CITY OF ALBUQUERQUE

March 20, 2015

**Re: Corrales Business Park
Conceptual Grading and Drainage Plan
Engineer's Stamp Date 3-19-15 (A14D011)**

## A1 GRADING AND DRAINAGE PLAN

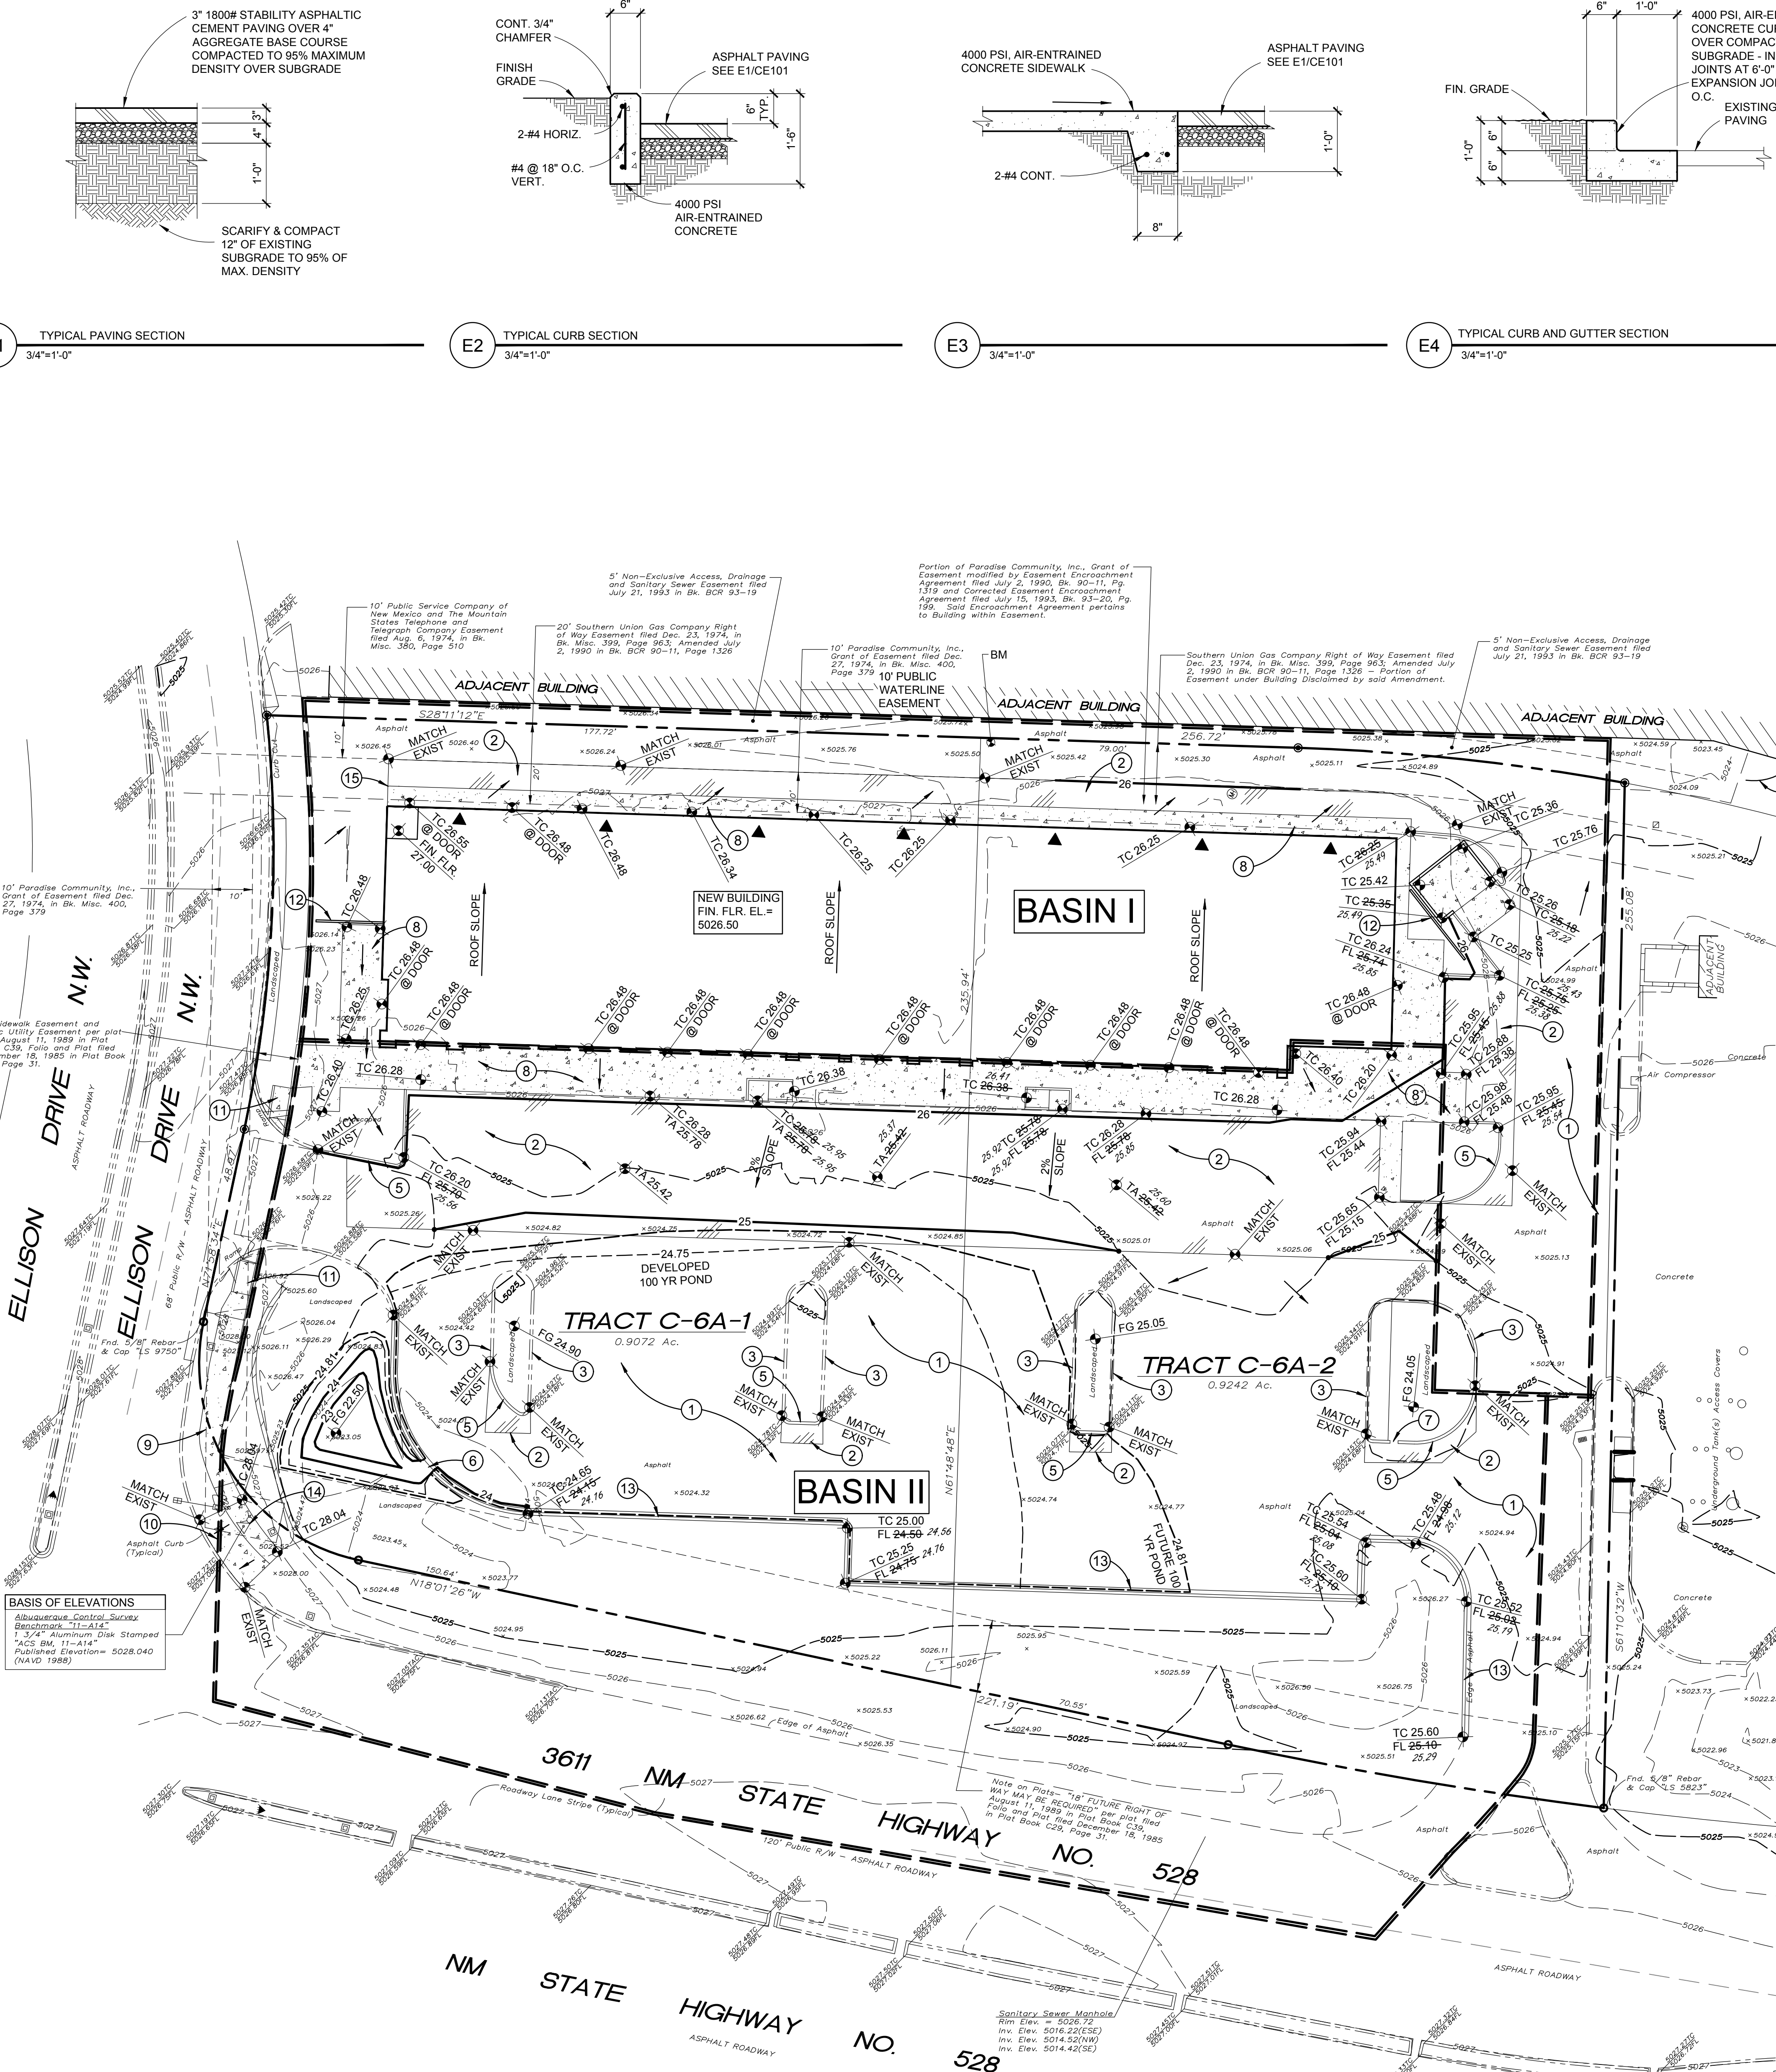
1. It appears that half of NM 528 drains into the site in the existing condition. Include this offsite basin in determining the WSE in Basin 2.
2. Provide a stage-volume table or calculations to support the ponding area and WSE in Basin 2.
